**From:** [REDACTED]  
**To:** [A303 Sparkford to Ilchester](#); [REDACTED]  
**Subject:** Re: A303 Sparkford to Ilchester - noise model Sparkford to Ilchester Dualling Project (TR010036) our ref Long Hazel Park 20014098  
**Date:** 09 January 2019 21:18:32  
**Attachments:** [Appendix C.odt](#)  
[Appendix D.pdf](#)  
[Appendix E.pdf](#)  
[Appendix F.odt](#)  
[Written Statement and Submissions.odt](#)

### **Impact of traffic noise from A303 improvements on Long Hazel Park, Sparkford for Mr & Mrs Alan Walton**

## **Sparkford to Ilchester Dualling Project (TR010036)**

#### **Written Statement and Submissions for Traffic Noise Mitigation by Mr and Mrs A Walton on behalf of Long Hazel Park and Long Hazel Lodges Limited, High Street, Sparkford, Yeovil, BA22 7JH**

Revision
C01

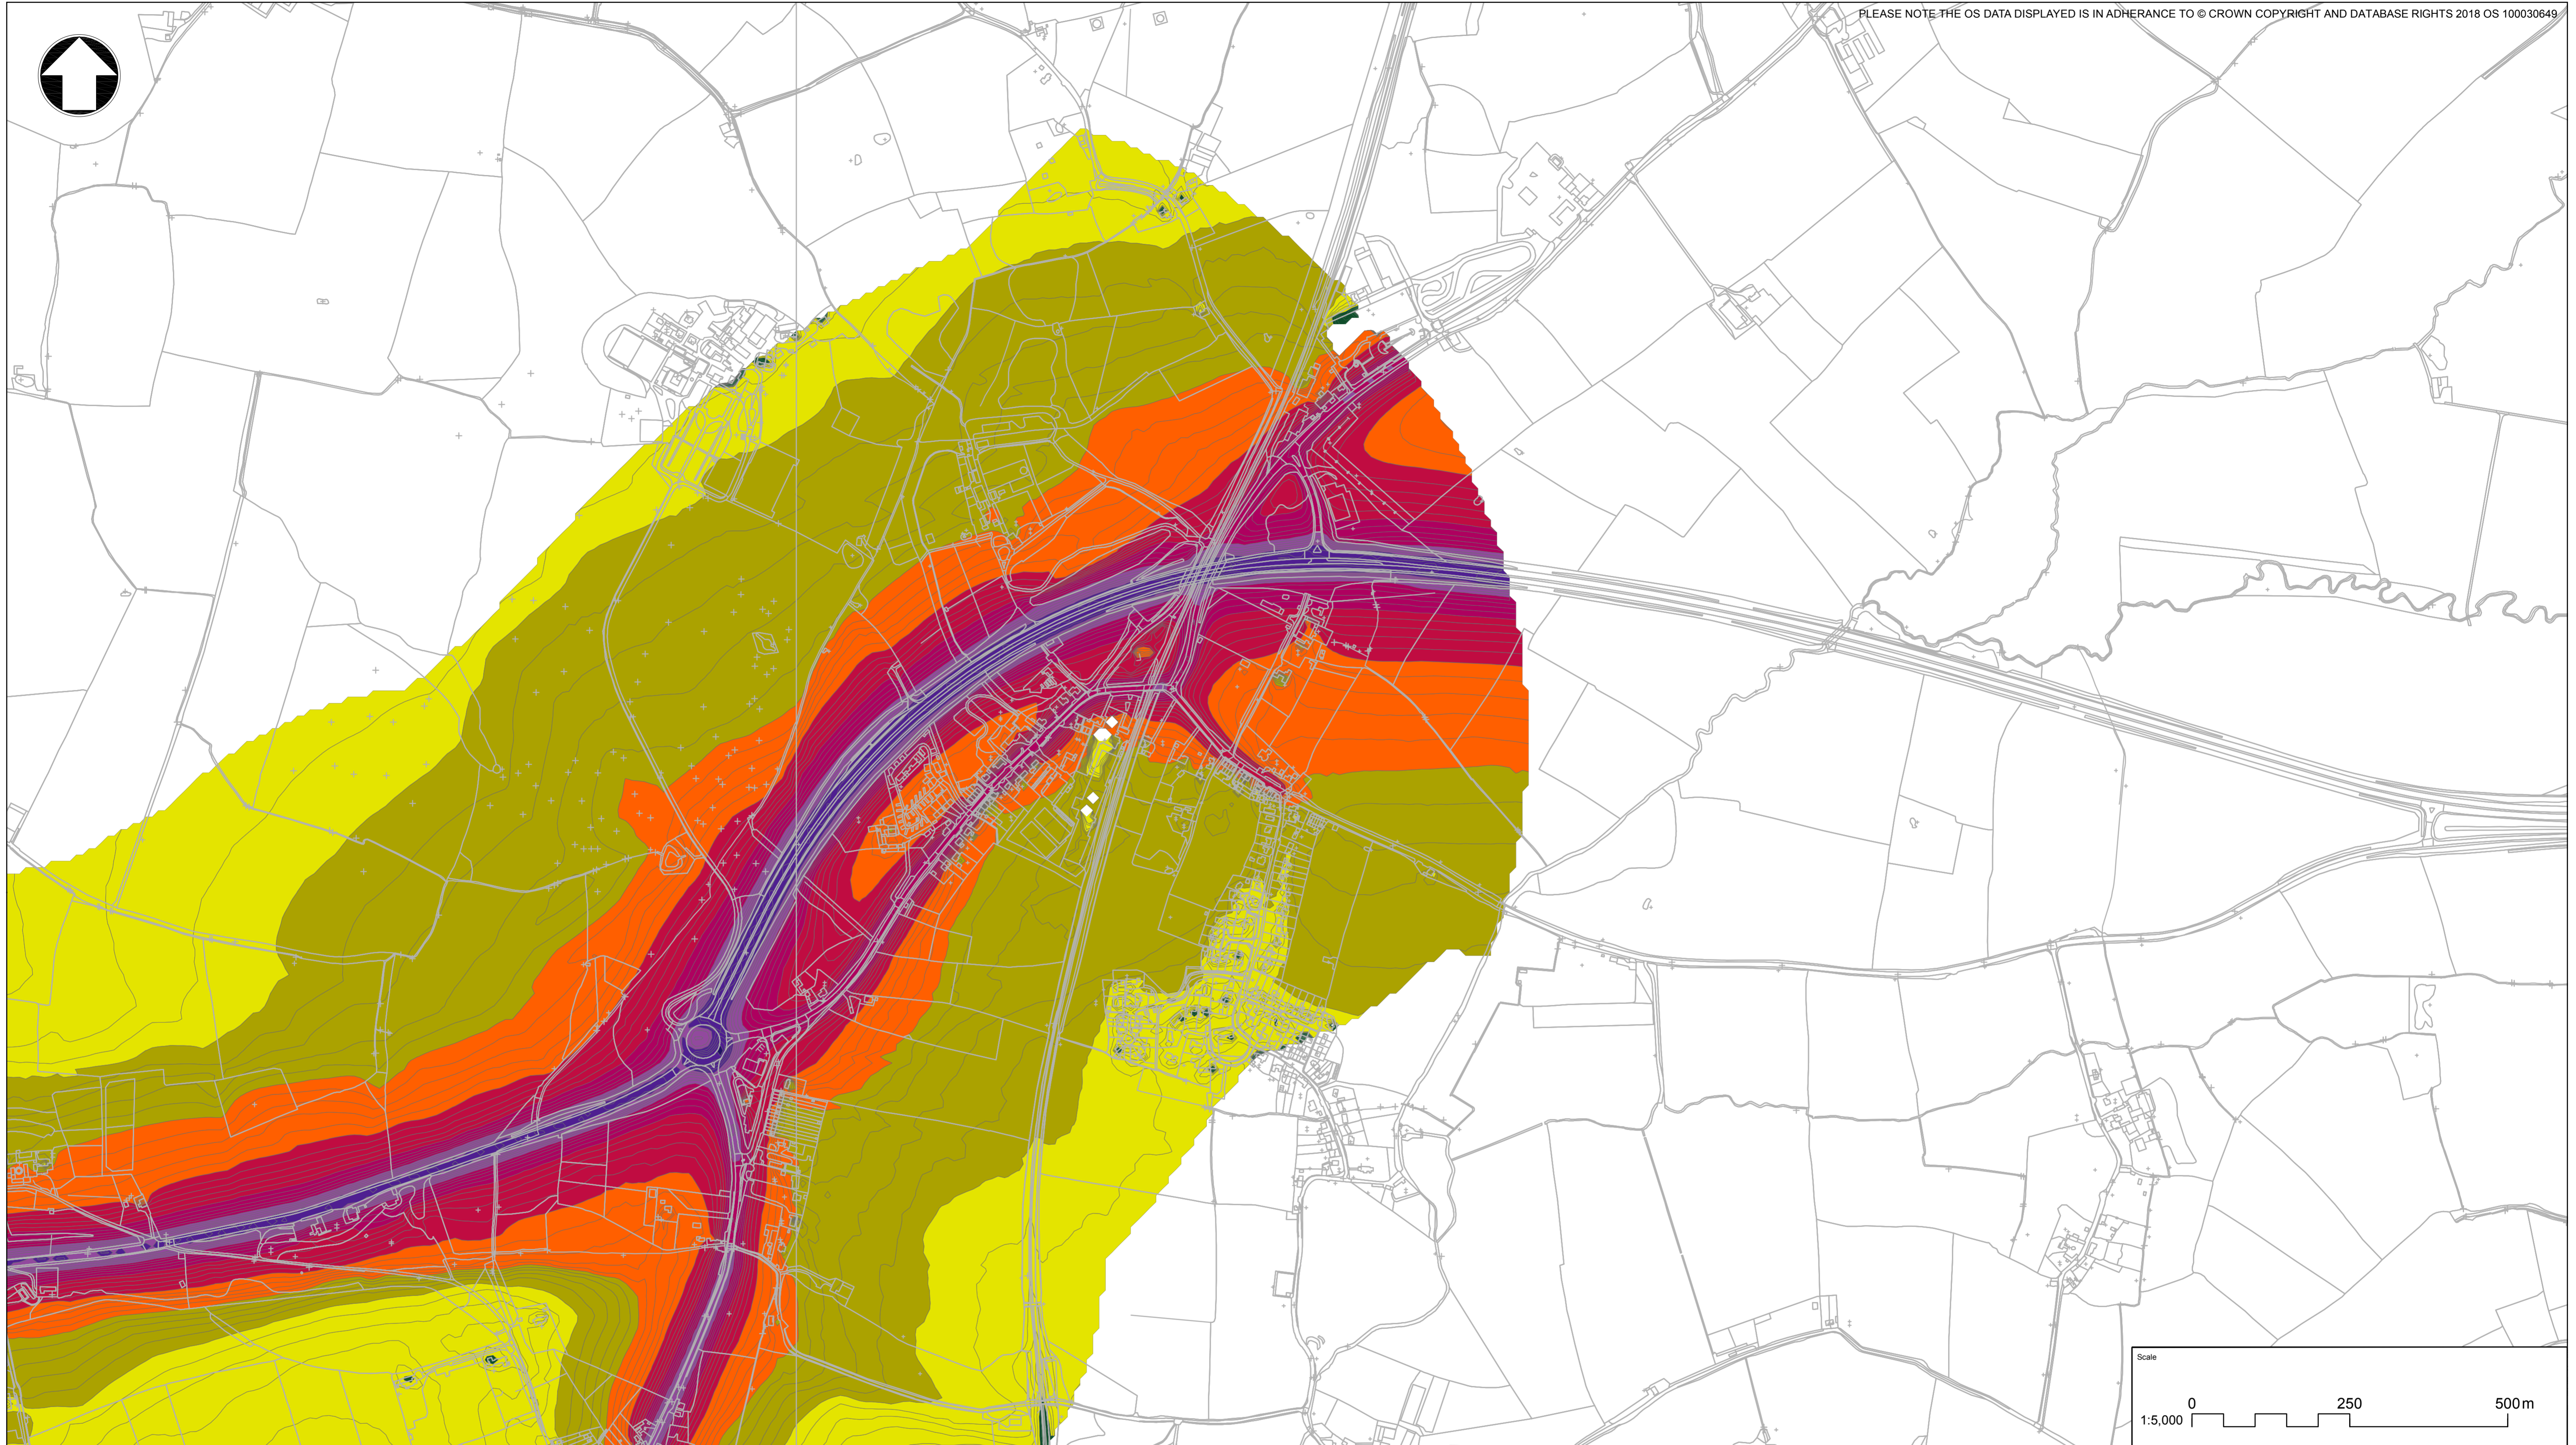
17. Both these areas fall within the applicant's various traffic noise models (sheet 4) which

illustrates projected traffic noise levels of between 55 and 75 decibels to which a factor of 3 decibels should be added as per the report of Mr Tegwyn Jones **Appendix C**.

19. The noise mitigation measures sought are a 3m high traffic noise acoustic barrier between points X and Y on the Plan **Appendix E** preferably extending to Point Z across the end of the adjoining track where it is proposed the footpath across the A303 will terminate. This section Y to Z would act as a bar to the public entering the A303 from this point should the request by the applicants that the pedestrian crossing be terminated. It would be far easier to construct the barrier on our side of the boundary whilst no development is taking place in relation to the six vacant plots closest to the A303. Should the applicant agree to construct the barrier as recommended by Mr Tegwyn Jones we would afford the applicant access to our property for this to be done. We would delay developing the six holiday lodge plots nearest to the A303 until after the completion of the barrier provided this is done before or at the same time that the whole scheme commences. Assuming that a traffic noise reduction surface is going to be provided on the new dual carriageway we would ask that in addition between the point where the new dual carriageway is grafted to the existing A303 at the mid northern boundary point with Long Hazel Park that this surface should be extended to just beyond the northern side slip road to the A359 at the very least. At the grafting point a change in traffic road noise at surface change will be evident and intrusive because unless the surface is all the same traffic will suddenly appear quieter and then be much noisier as it passes on to the untreated surface. We understand this could be by up to 8 decibels in difference. Hopefully the road surface incorporating a traffic noise reduction coat will be upgraded to link up with the recently reduced noise surface at Chapel Cross which continues on to Wincanton. Where possible a reduction in speed limit could be imposed say to 50mph on the new proposed west bound slip road to Hazlegrove Roundabout for Sparkford Village as well as a noise reduction surface. This proposed slip road is presumed to commence in the vicinity of the northern boundary of Long Hazel Park with the A303 and this speed limit with appropriate noise reduction surface will mitigate traffic noise for the benefit of the village as well. It is also requested that an acoustic noise reduction barrier be erected along the length of the said slip road and corresponding barriers on the A303 west bound at Camel Hill especially where the road section is elevated. This is because the prevailing wind from the west blows the traffic noise in to our park and is a constant irritation to our guests and ourselves.
